Project#1008630 Manzano Mesa Tract(s) C
13DRB-70741 Preliminary/Final Plat Approval

9. **Project# 1008630**
13DRB-70682 MINOR - PRELIMINARY/
FINAL PLAT APPROVAL

RE: Tract C, Manzano Mesa

PLAT FOR
TRACT C-1
A REPLAT OF TRACT C AND VACATION OF
PORTION OF JUAN TABO BOULEVARD SE
PORTION OF SOUTHERN BOULEVARD SE
MANZANO MESA
WITHIN SECTIONS 27 AND 28,
T. 10 N., R. 4 E., N. M. P. M.
CITY OF ALBUQUERQUE
BERNALILLO COUNTY, NEW MEXICO
AUGUST, 2013

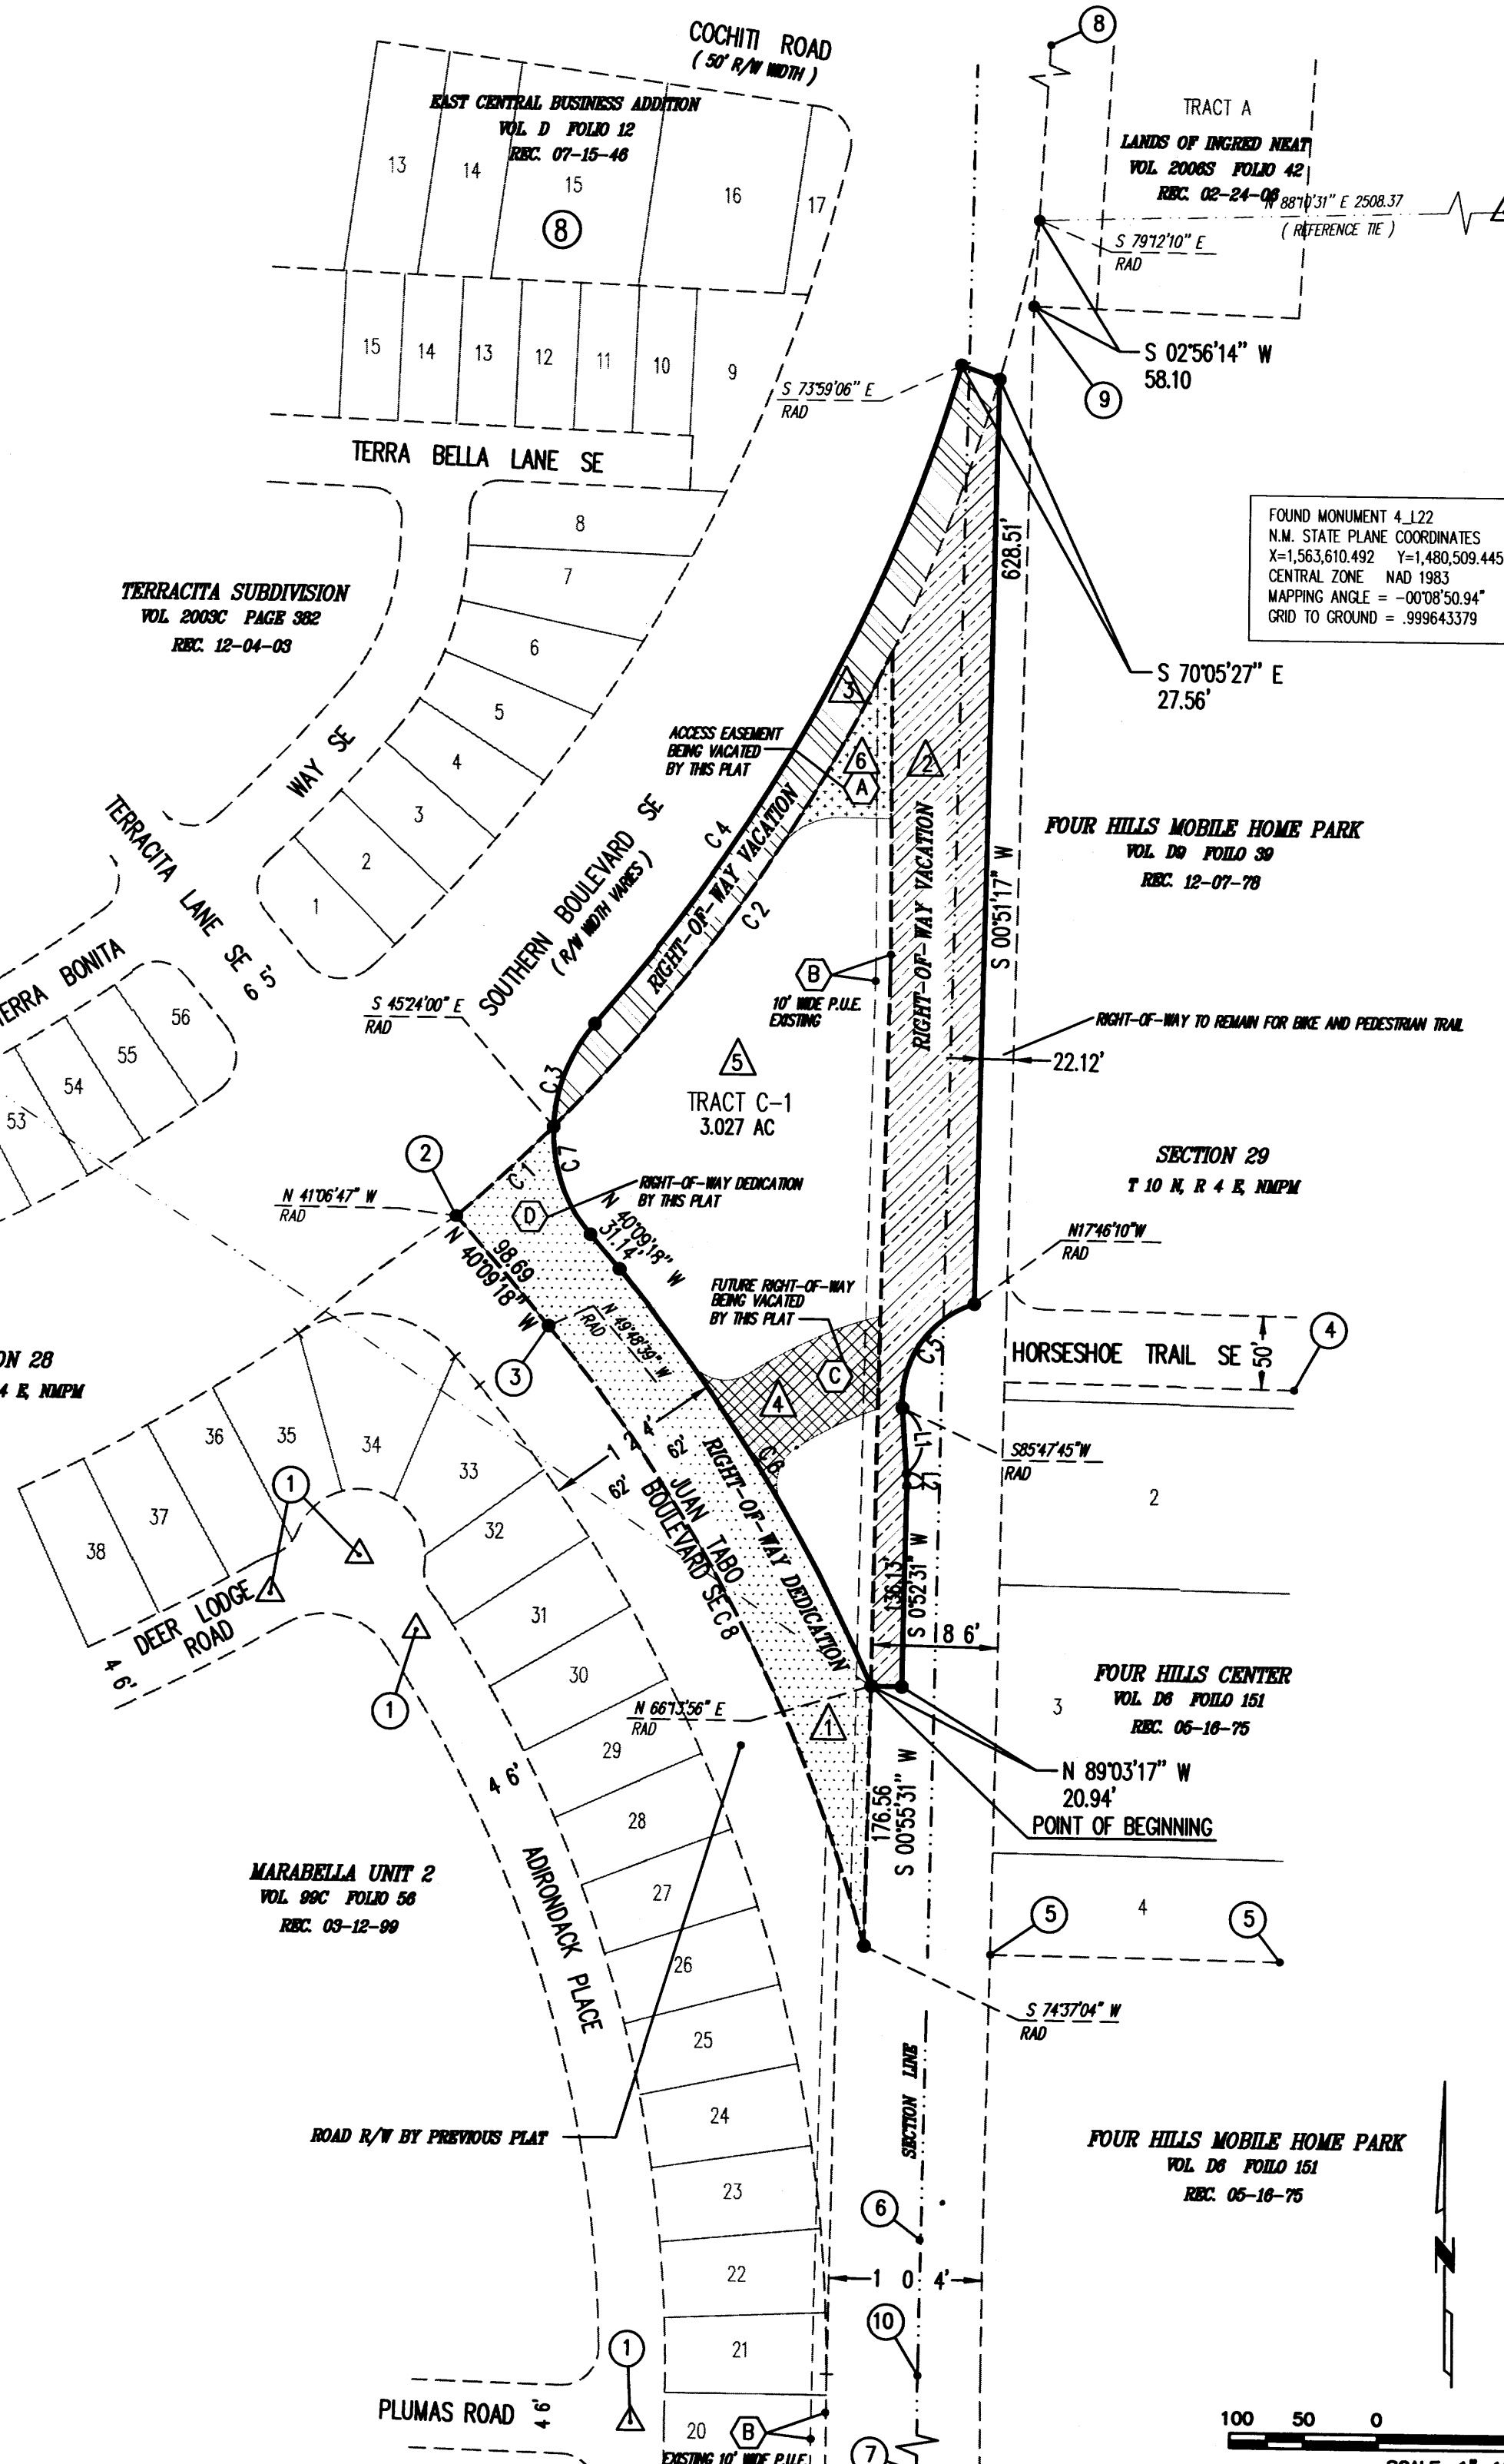
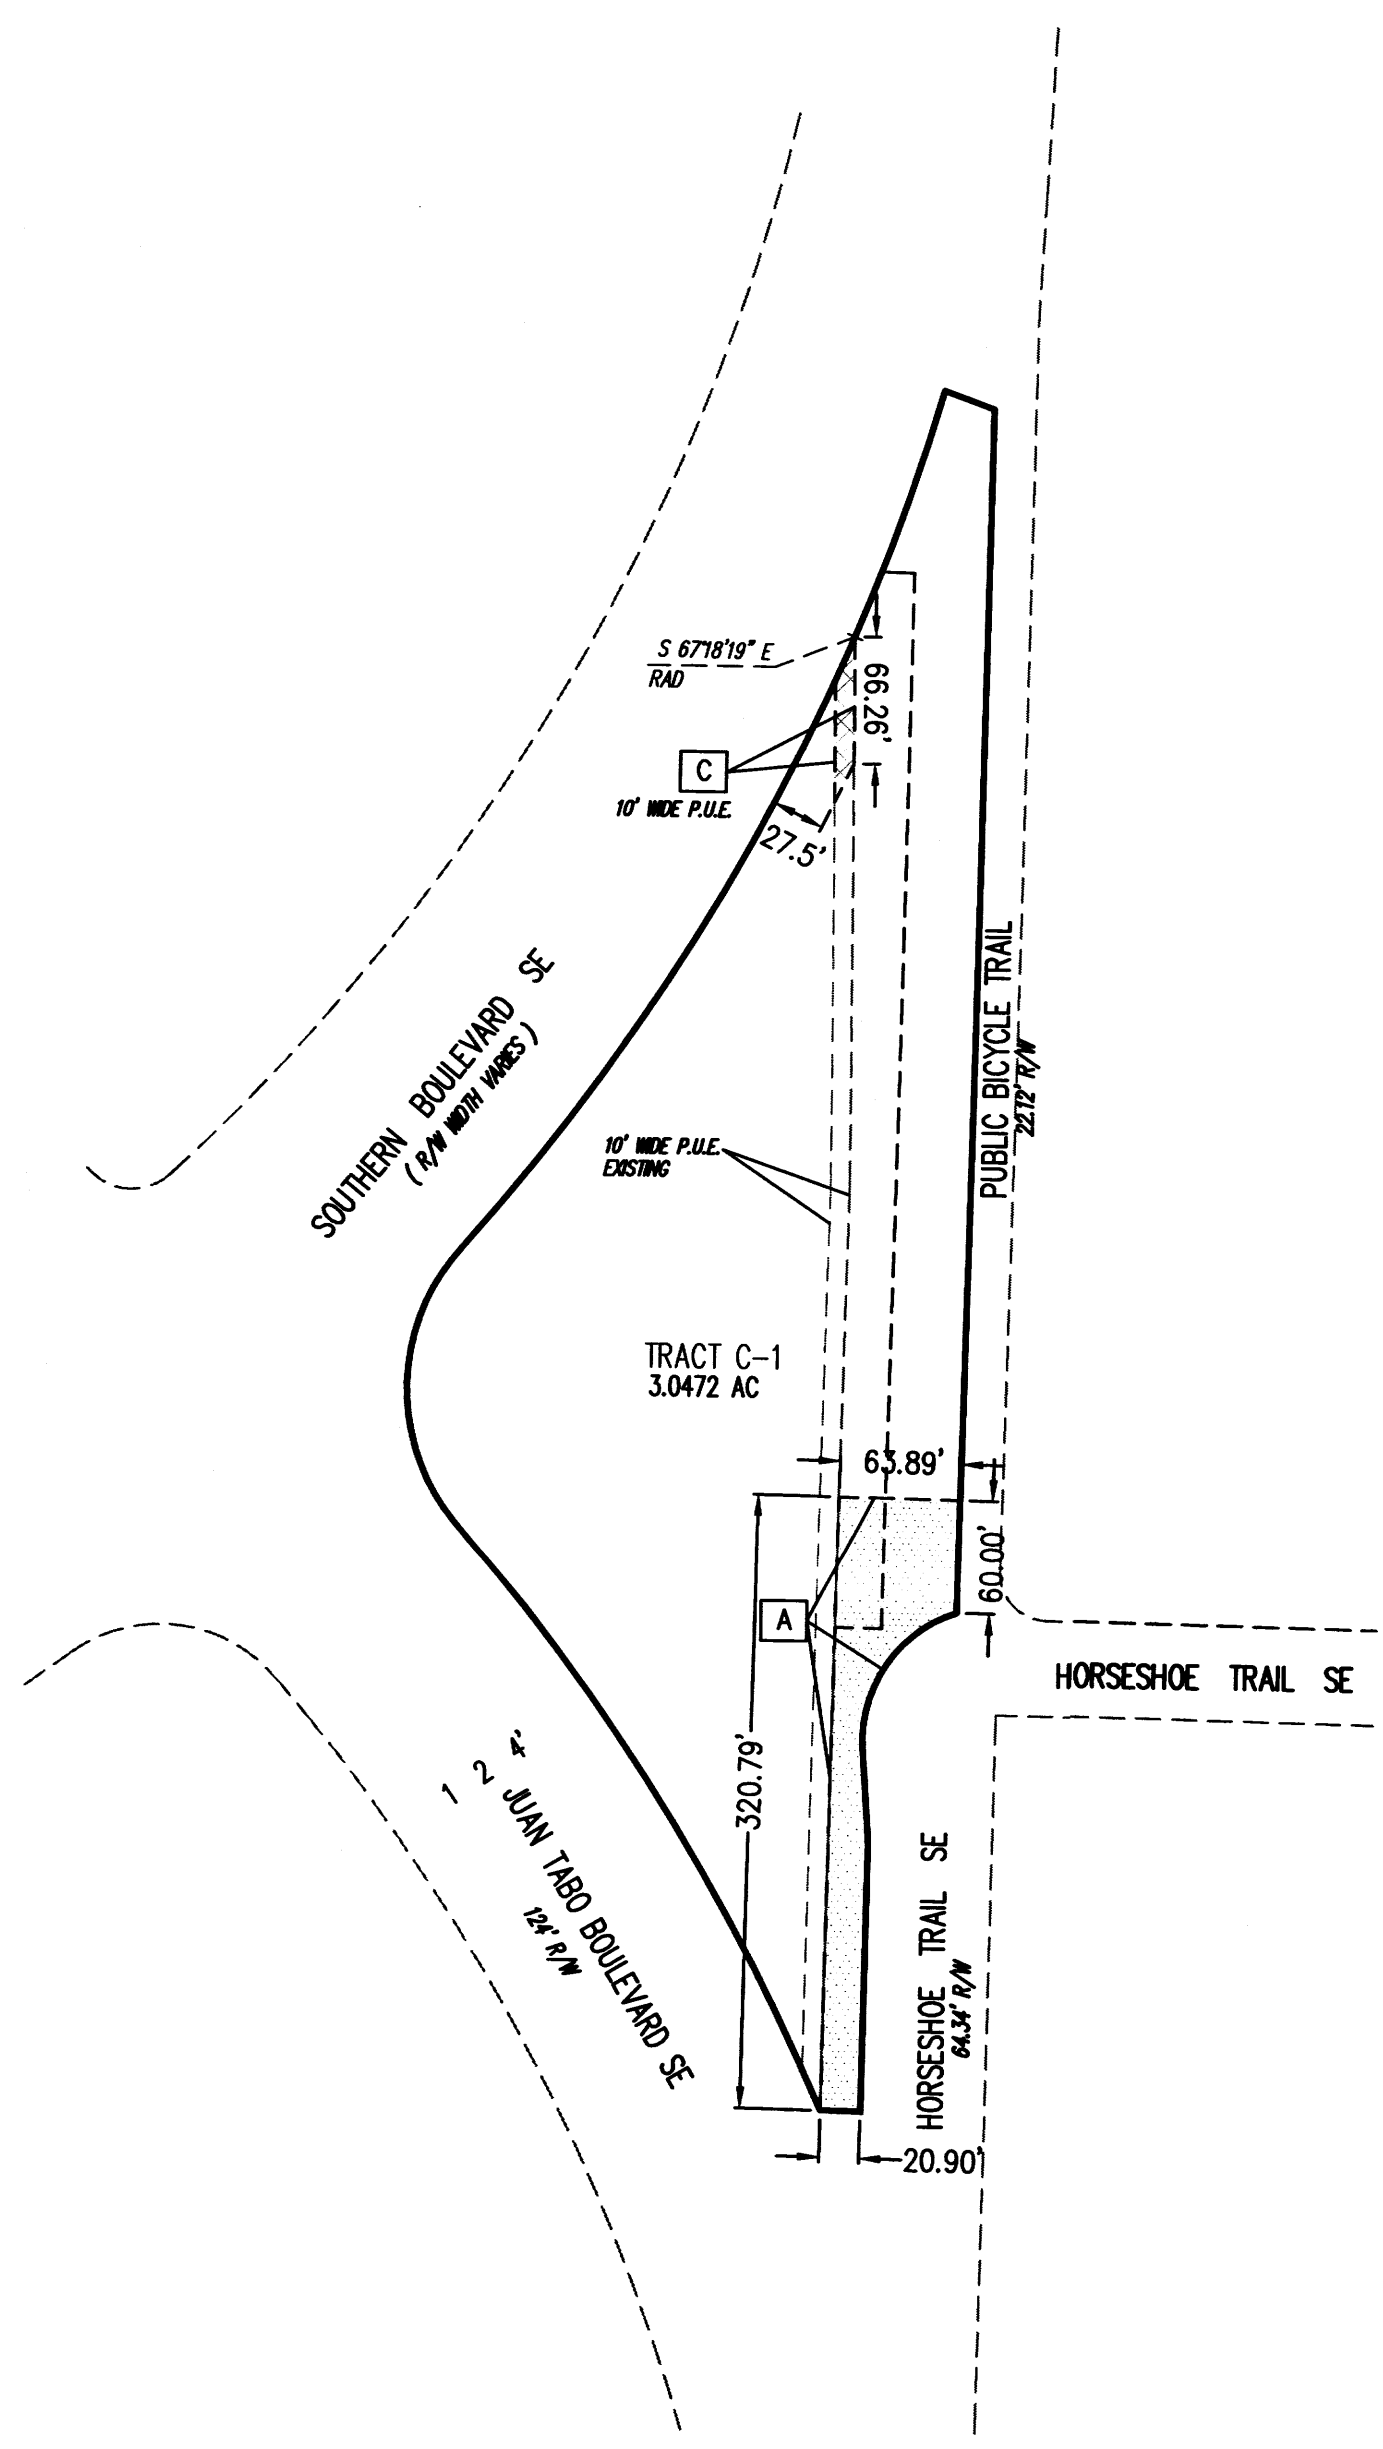
Proposed plat does not conform to Sketch Plat – the City does not normally leave a portion of right of way. More information/ field data is needed, plus a written commitment from DMD for maintenance of proposed Bike Trail right of way. Real Property must sign the plat to acknowledge disposition of vacated right of way.

Plat boundary lines do not clearly show existing tract, and the legend does not distinguish between Disclosure Statement (?) 2 and 3, or 4 and 6.
